Application No: R/28/21/L
Site Address: 2 Manor Cottages Preston Paddock Rustington BN16 2AF
Description of works: Listed building consent to replace 2 No. existing timber casement windows in white finish to be replaced with timber casement windows in arctic white finish .

Thank you for your internet representation made on 7th March 2021 which has been recorded as an objection with the comments as follows:

Drawing Title:
Proposed timber casement windows

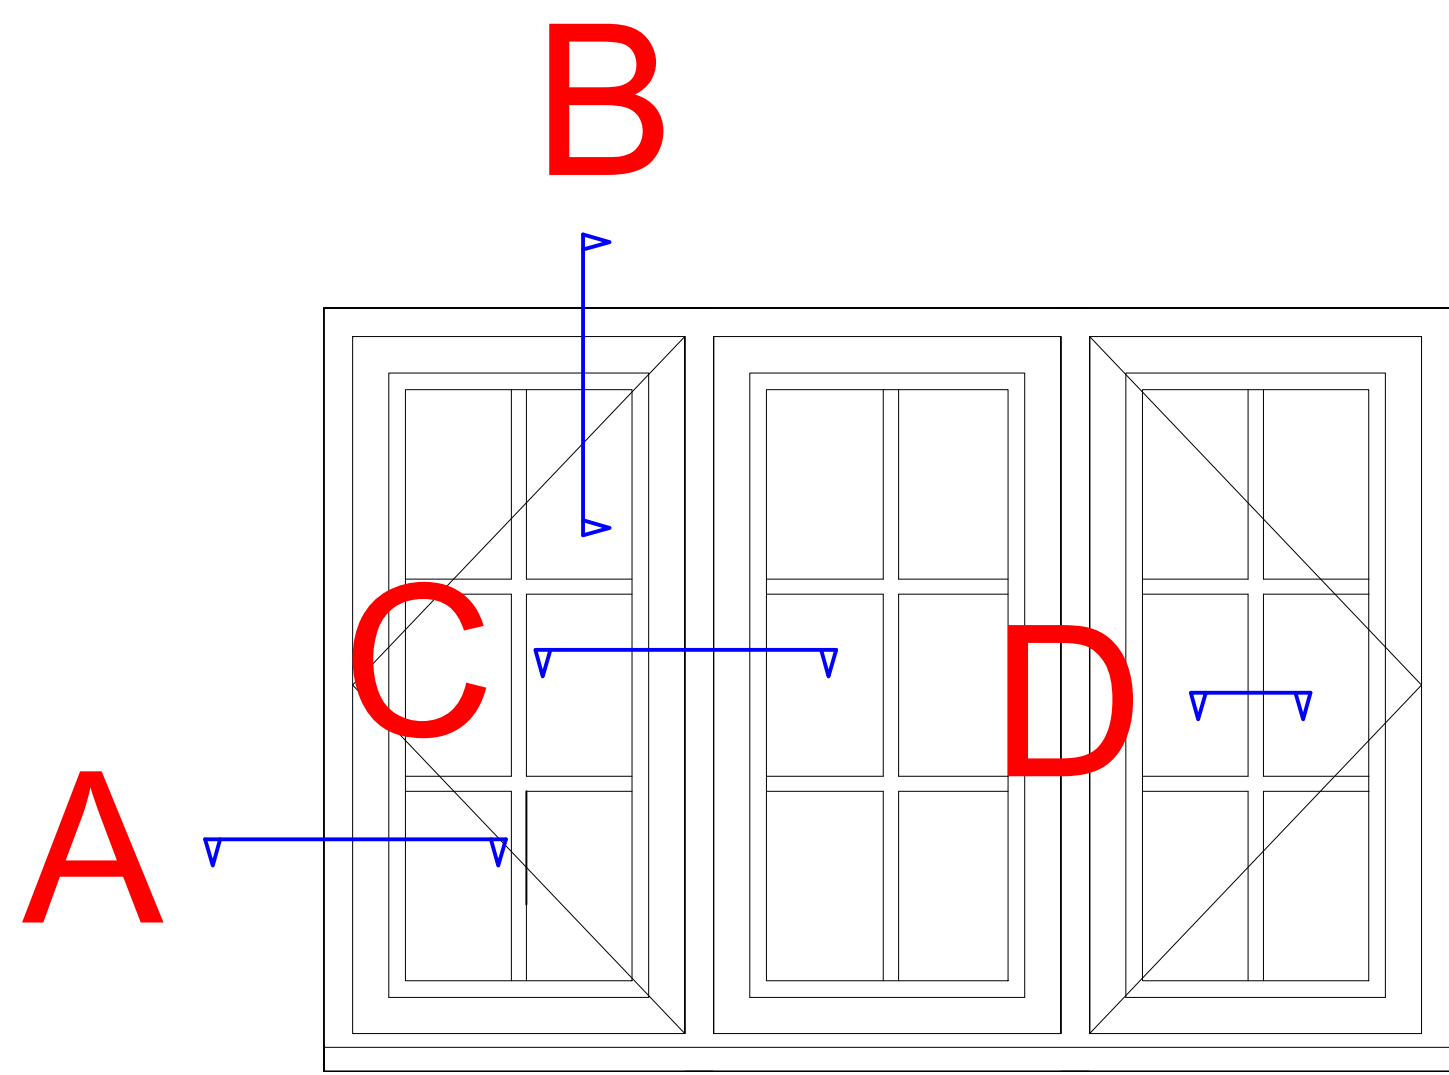
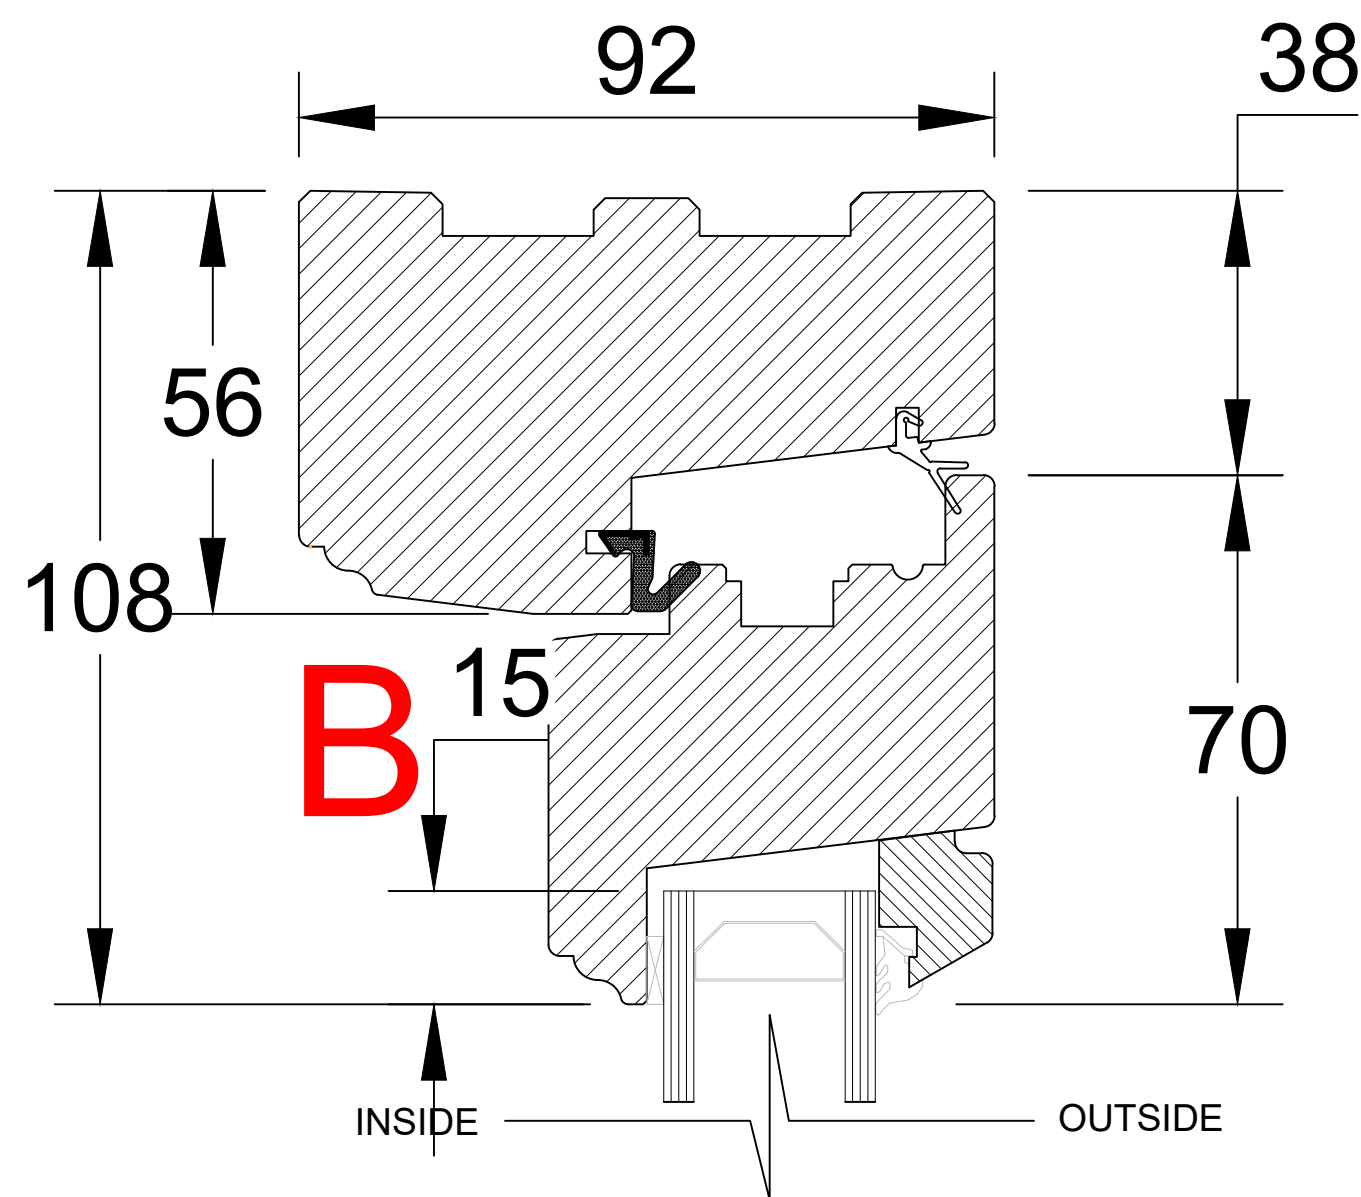
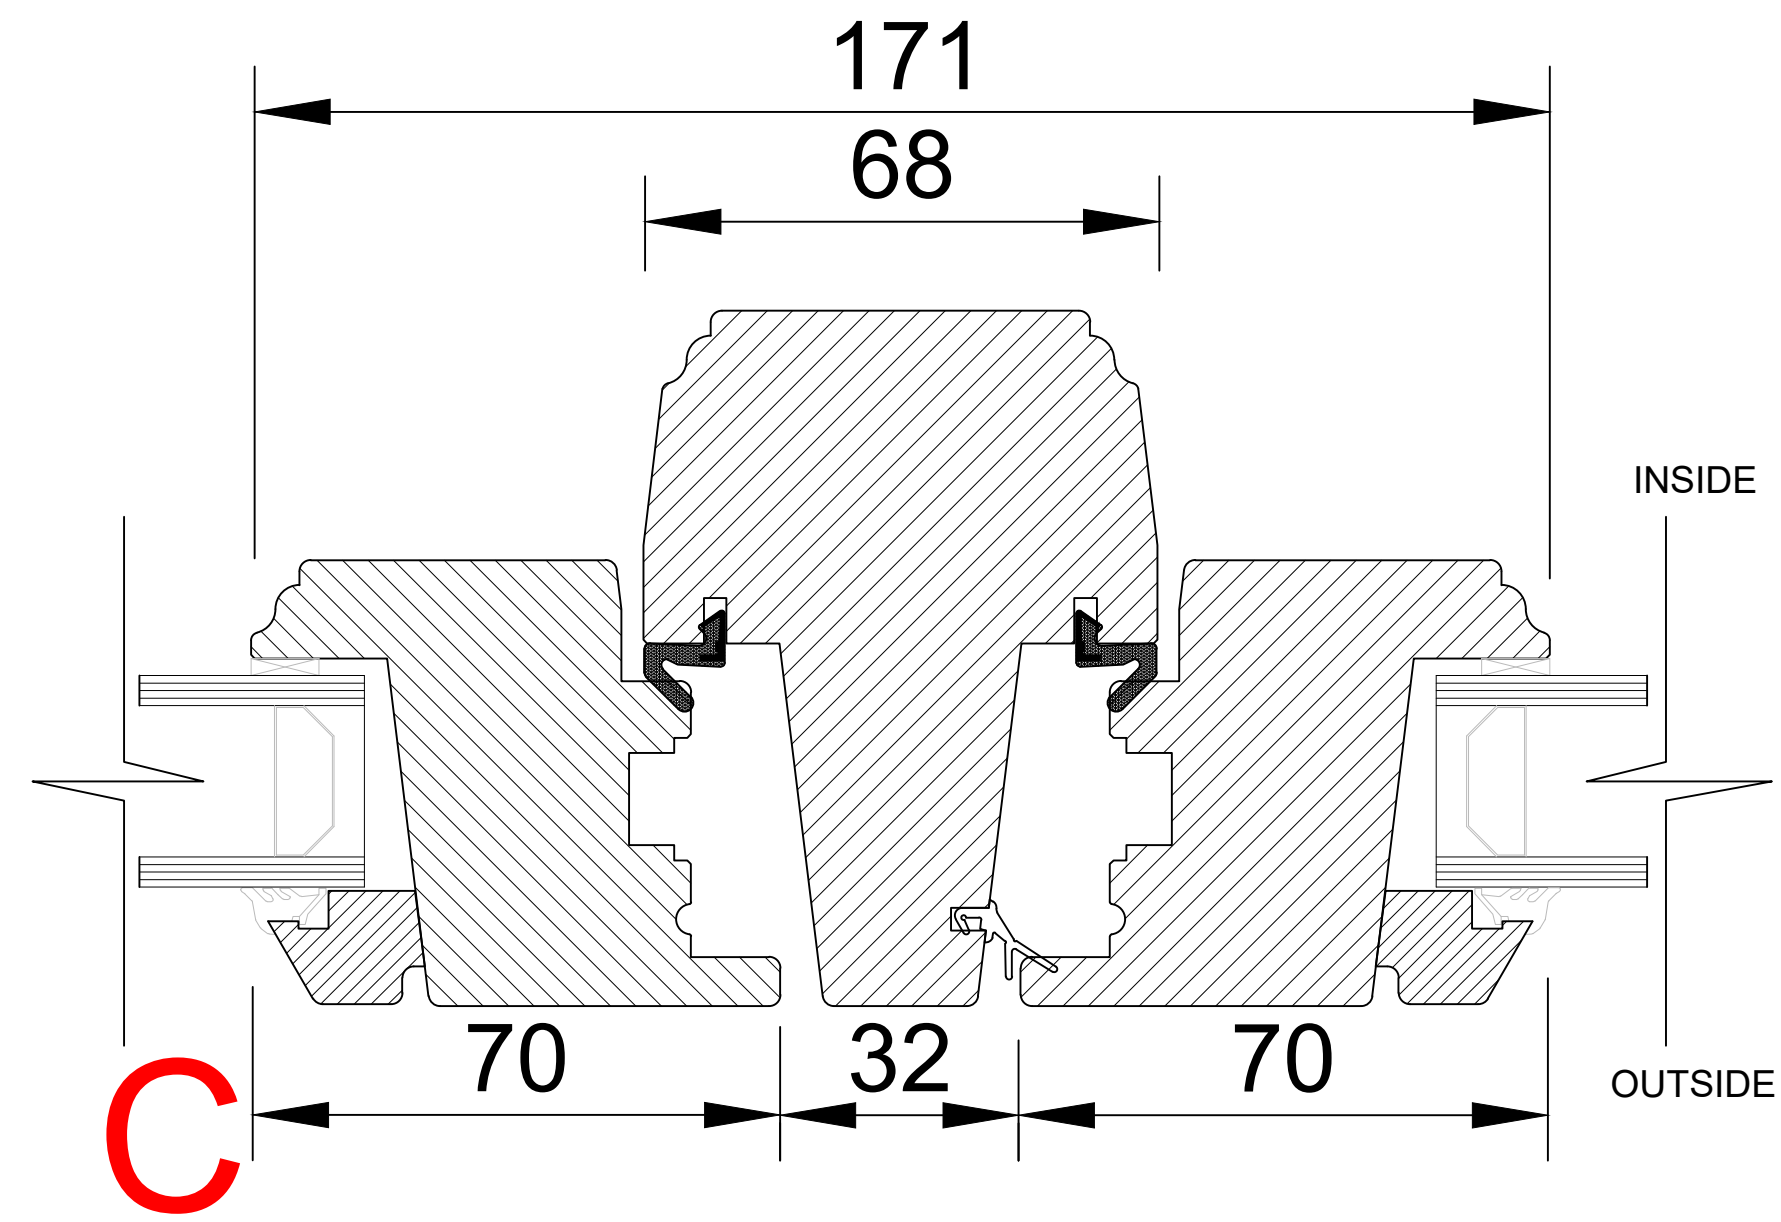
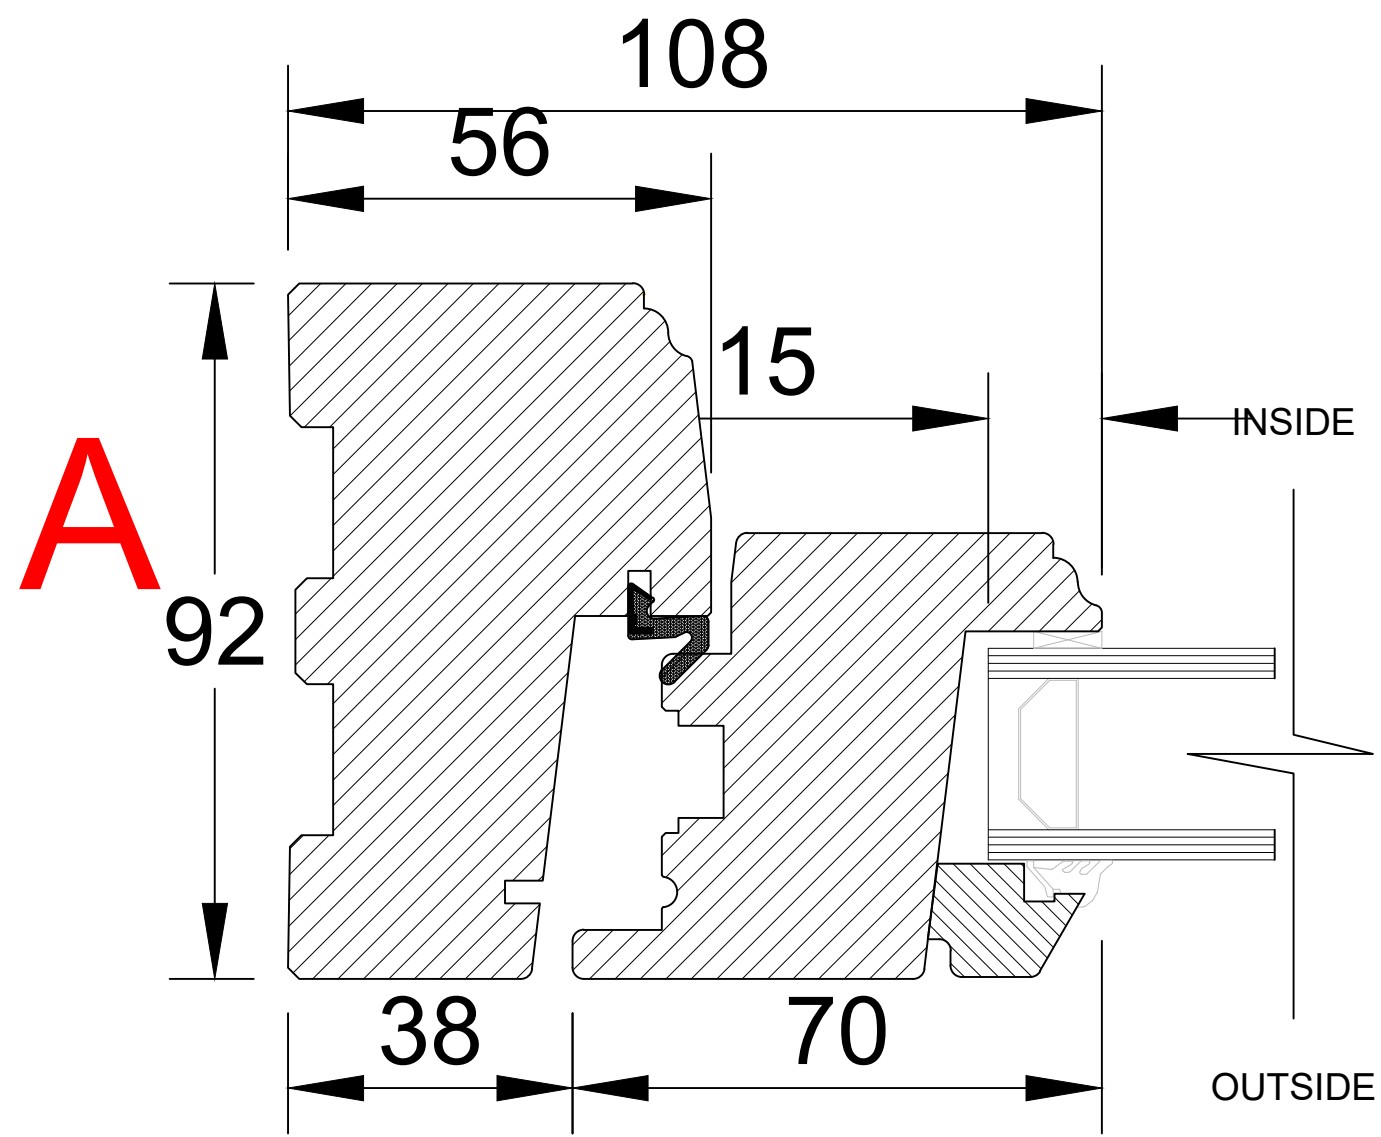
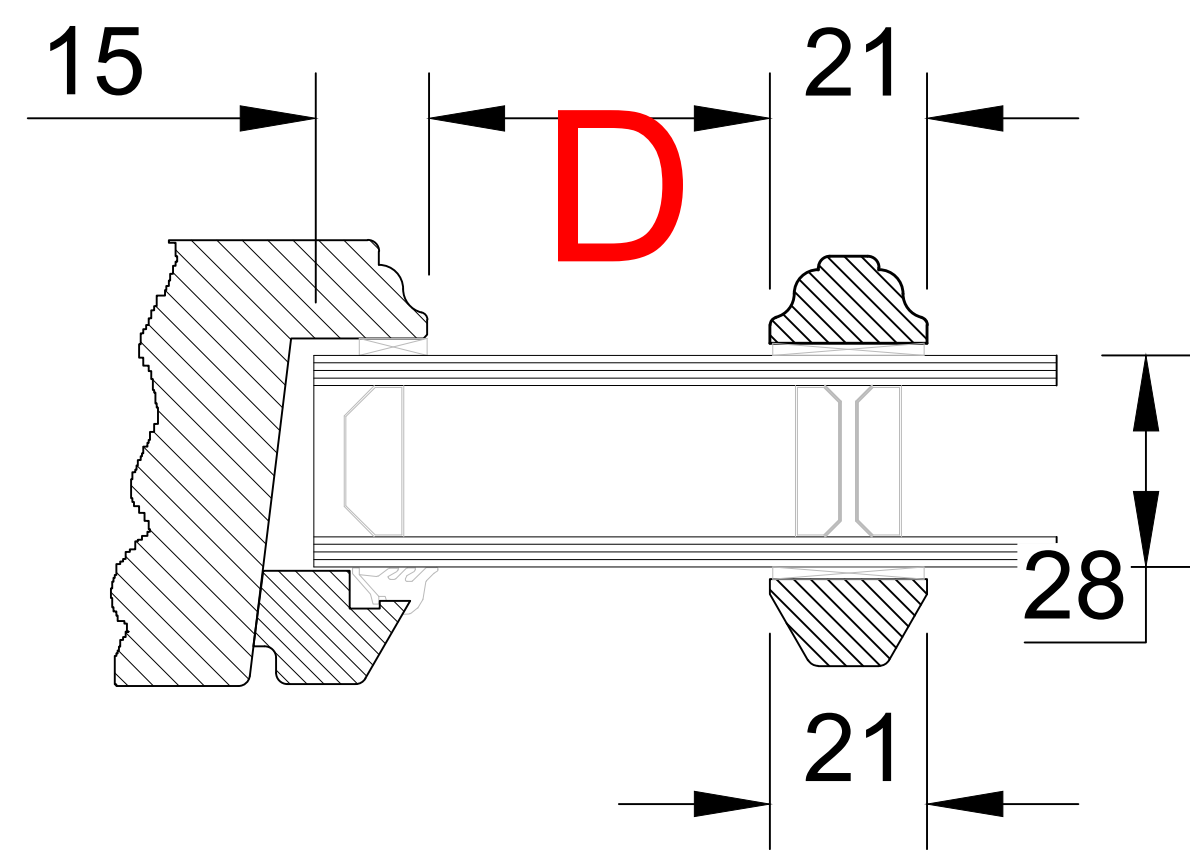
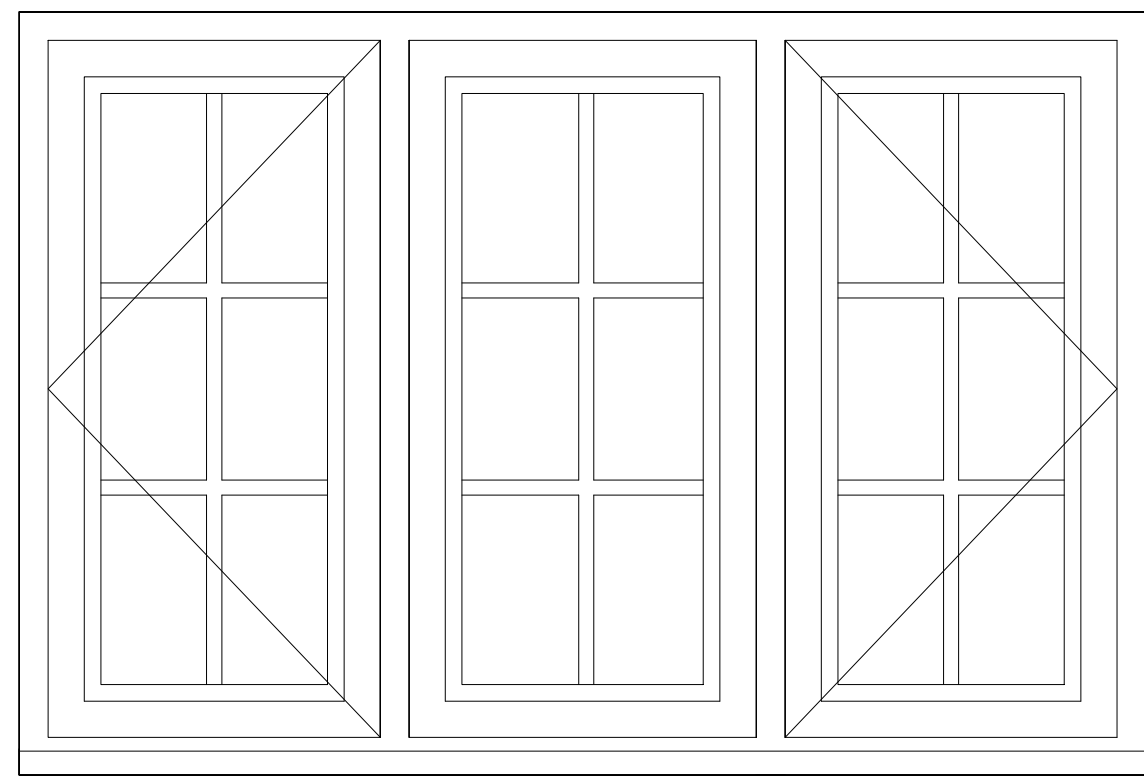
The proposed replacement timber casement windows are not of traditional design and detailing. For instance they incorporate standard depth double glazed units, thermal spacers, dead flat glazing, false glazing bars and lack the subtlety of detailing and profiles of the originals. As such they will detract from the character and appearance of the listed building in particular and the conservation area in general.

There are no compelling reasons given as to why double glazed units should be used but if the Council, in this particular instance, considers that double glazed painted timber side hung casements can be granted consent then it is strongly recommended that slim glazing units of approximately 12mm depth should be used with properly formed glazing bars and that all timber joinery profiles and detailing must match the original windows.
